Recommendation Report for Planning Permission for Works or Extension to a Dwelling

REF NO: EG/63/18/HH

LOCATION: 40 Elm Grove
Barnham
PO22 0HL

PROPOSAL: 2no. front extensions, new roof to include accommodation at first floor level & internal alterations throughout.

DRAWING
Proposed
Plans & Elevations

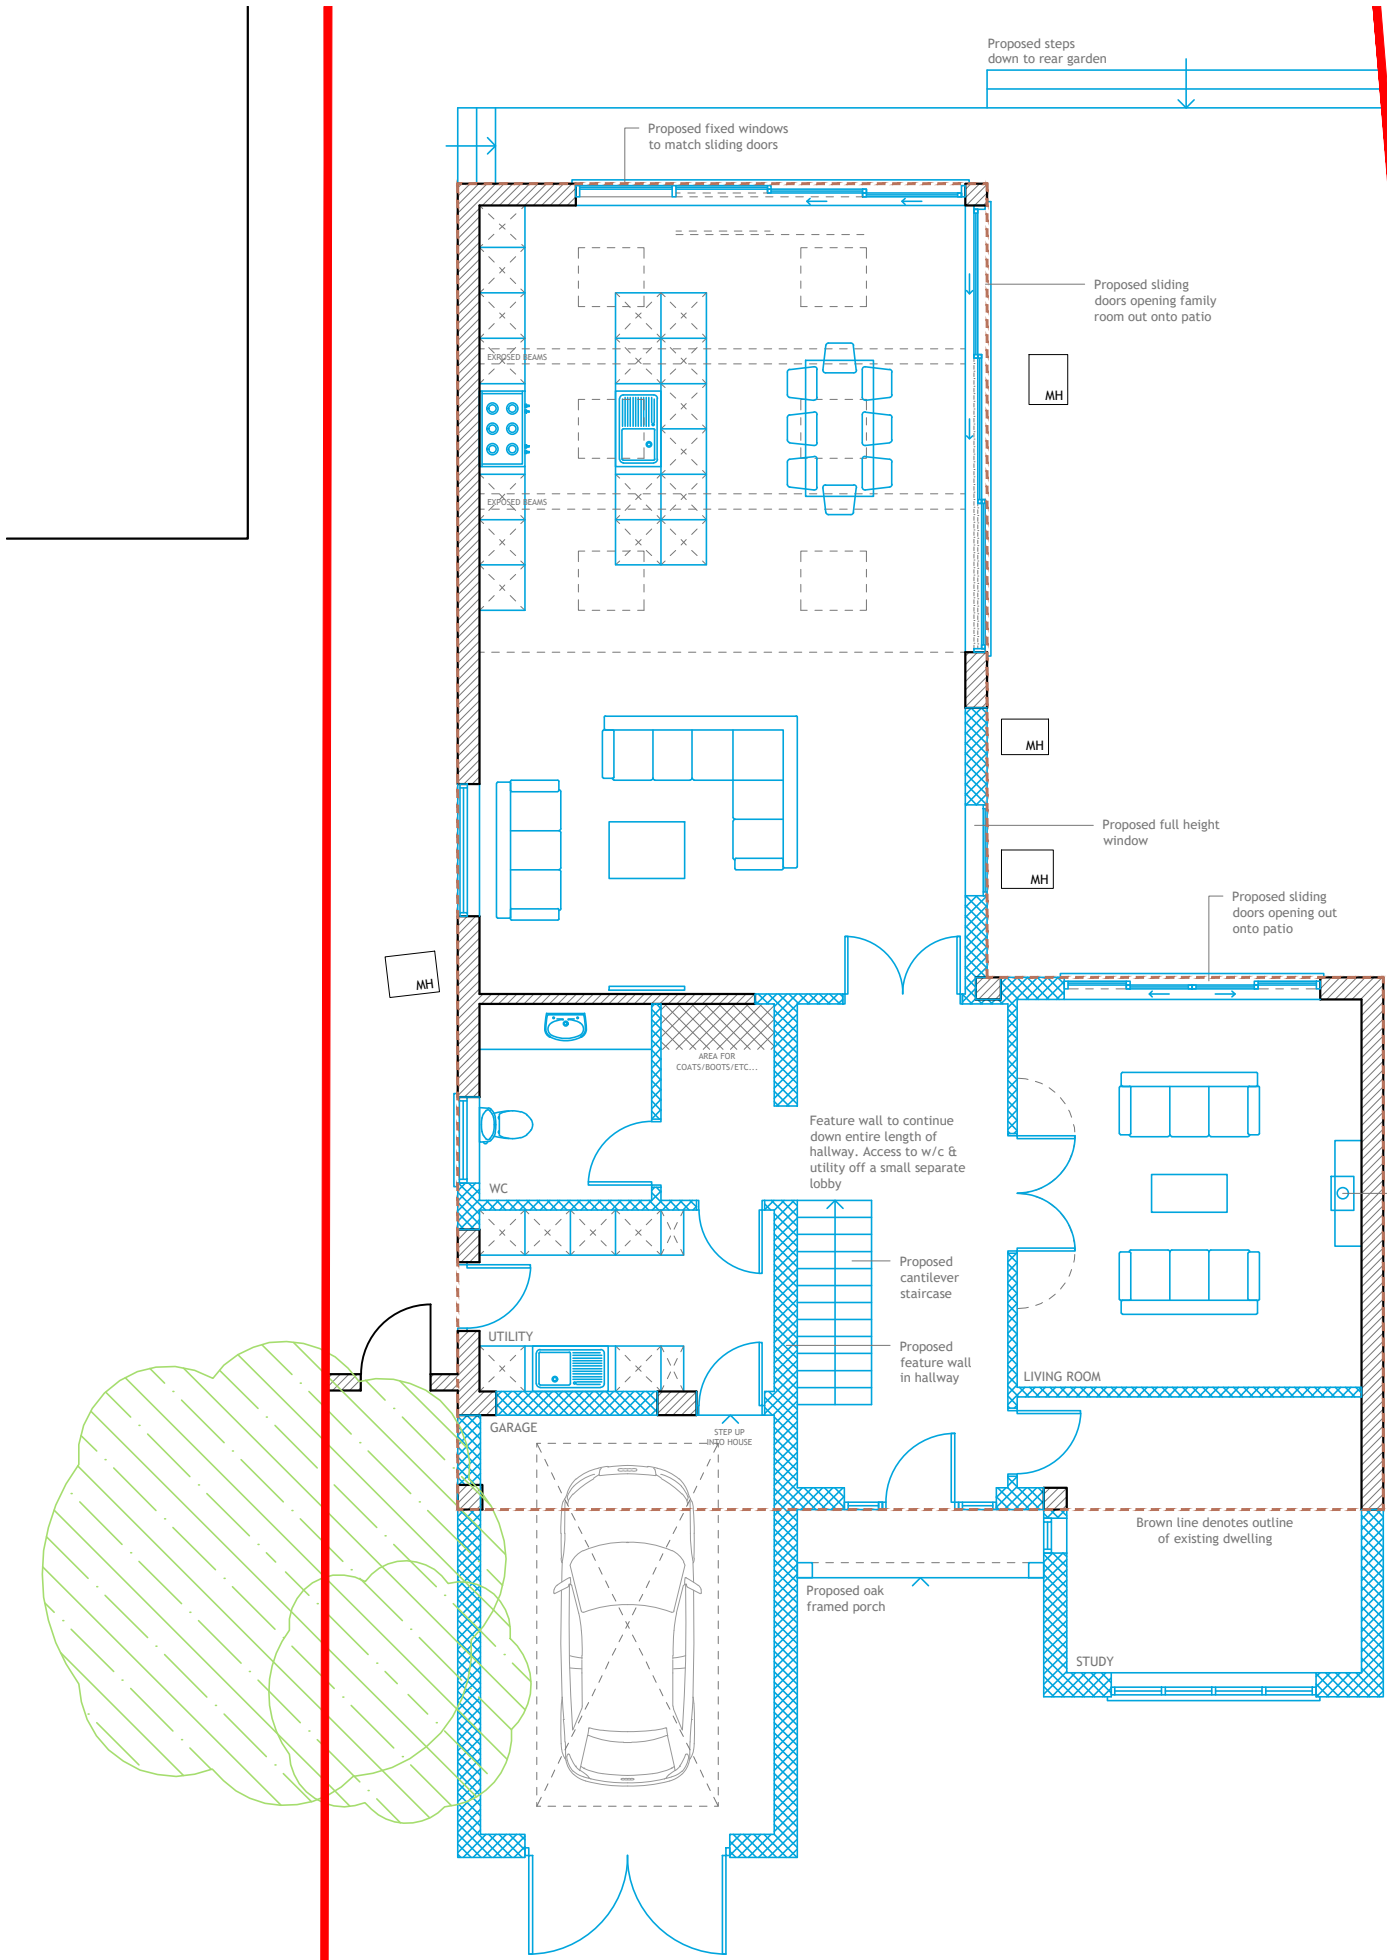
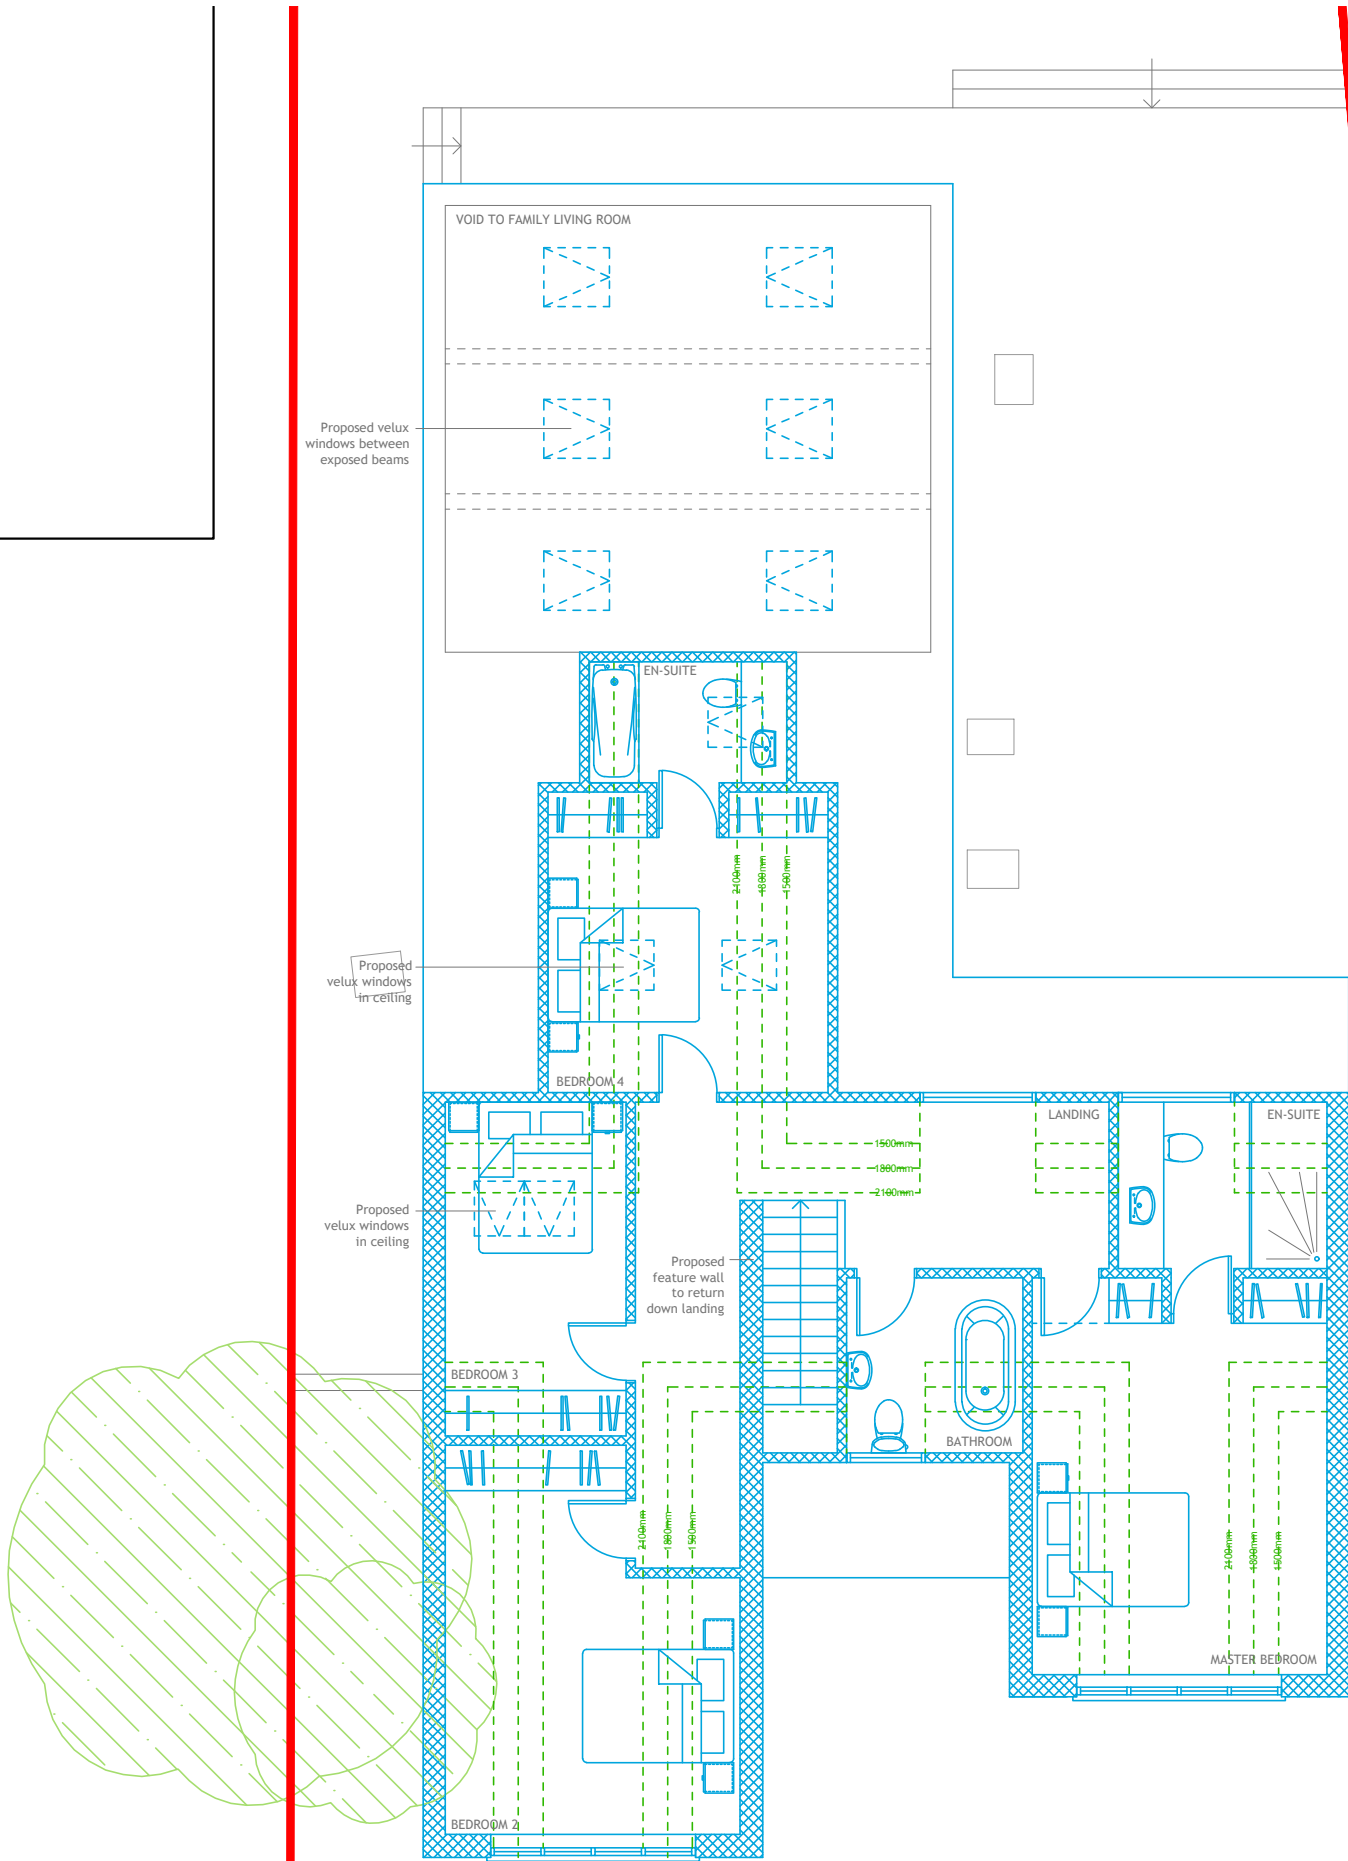
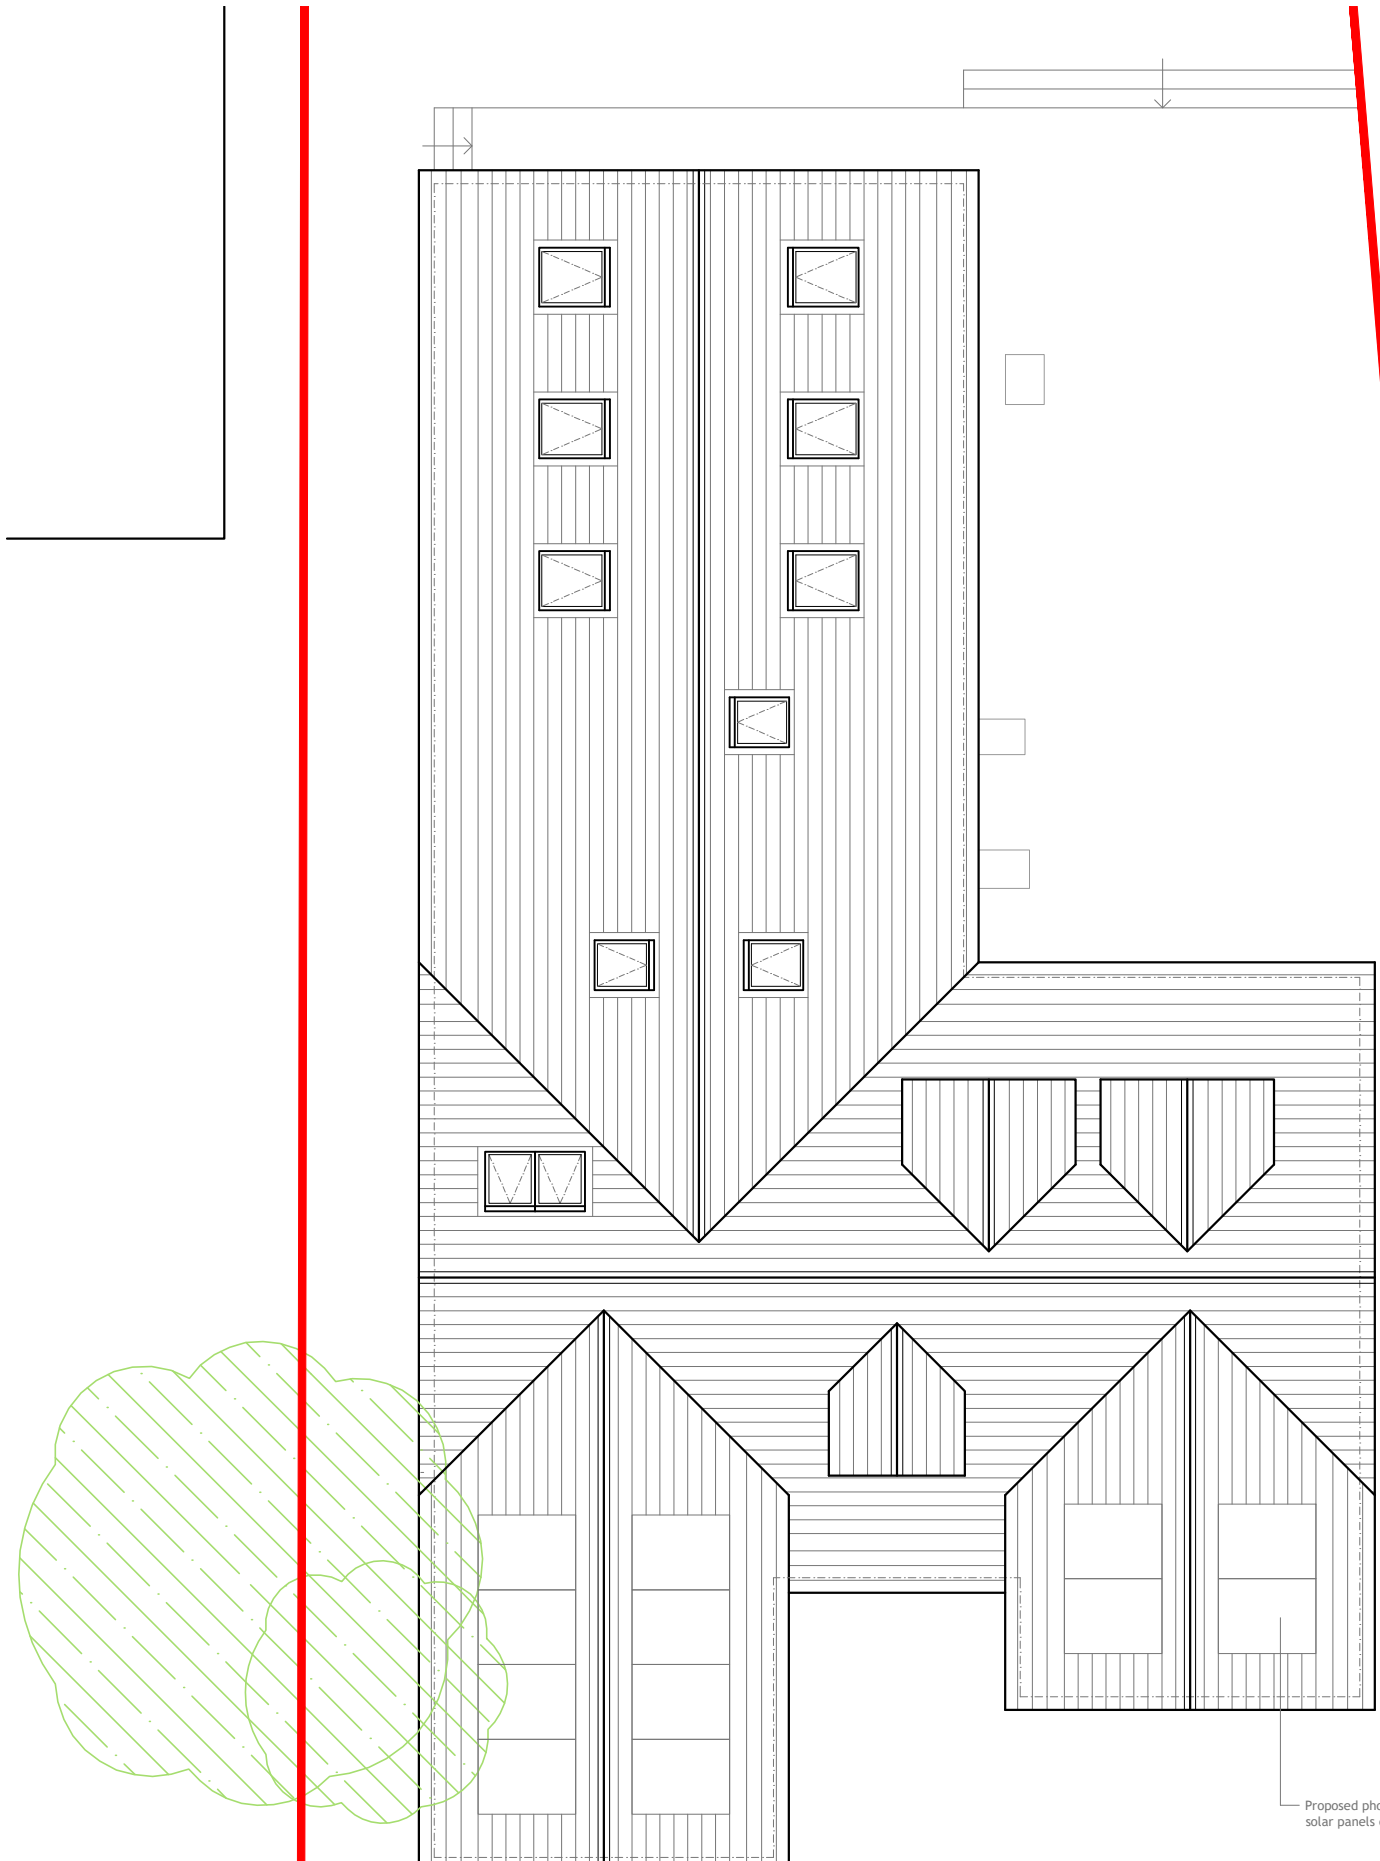
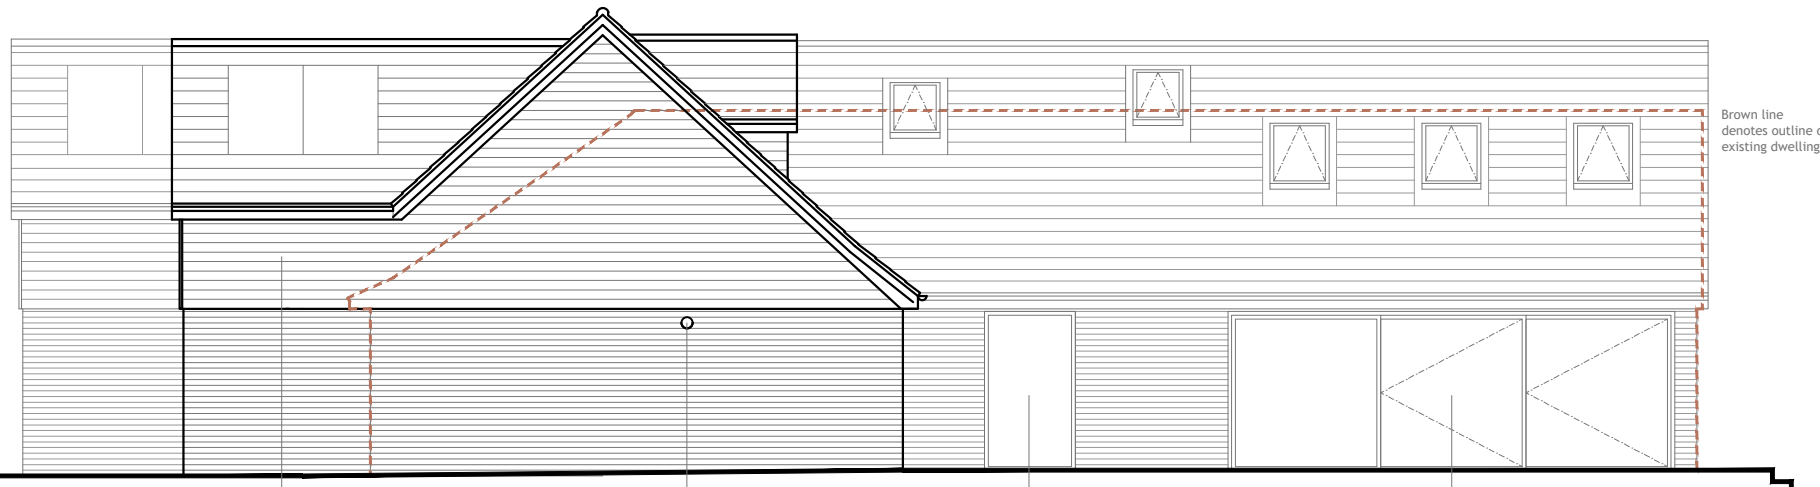
The development consists of extensions which would project forward of the principal elevation of the dwelling. However a minimum of 9.4m is retained to the front boundary and due to the siting of the dwelling it does not extend beyond the established property line in the locality.

As the proposal increases the total ridge height of the host dwelling, it cannot be considered a subservient addition and therefore is in conflict with DDM4(b), however the development does appear well integrated and as the surrounding area consists of a variety of design and styles with single and two storey properties the development is not out of keeping with the area.

The development consists of extensions which extend approximately 4.6m and 2.5m in front of the principal elevation of the dwelling with gable roofs to a height of around 5.7m. The proposal also creates rooms in the loft space by increasing the total ridge height of the host dwelling by approximately 1.3m, resulting in a total height of around 6.2m. Eaves height will remain as existing.

There will be 2 dormers to the rear with a height and depth of 2m which may have the potential for slight overlooking to the property to the north east, however as the windows do not serve principal rooms (landing and bathroom) the impact of any potential overlooking would not result in such harm that a refusal could be justified.

There will be a window and sliding doors to the eastern and northern elevation however at single storey level, views will be of the rear garden. There will be also 4 velux windows installed to the side elevations however due to their location in terms of the height in that they are above 1.7m from the finished first floor level, they are not considered to give rise to any loss of privacy or overlooking. 6 velux and a large set of windows are proposed to the 1st floor rear elevation however they serve a void area and therefore again are not considered to give rise to any overlooking.

Solar panels are proposed to the front gable roofs however due to their siting are not considered overbearing and with sufficient boundary treatment to the front side boundaries it largely restricts any view of the development and solar panels from the neighbouring properties.
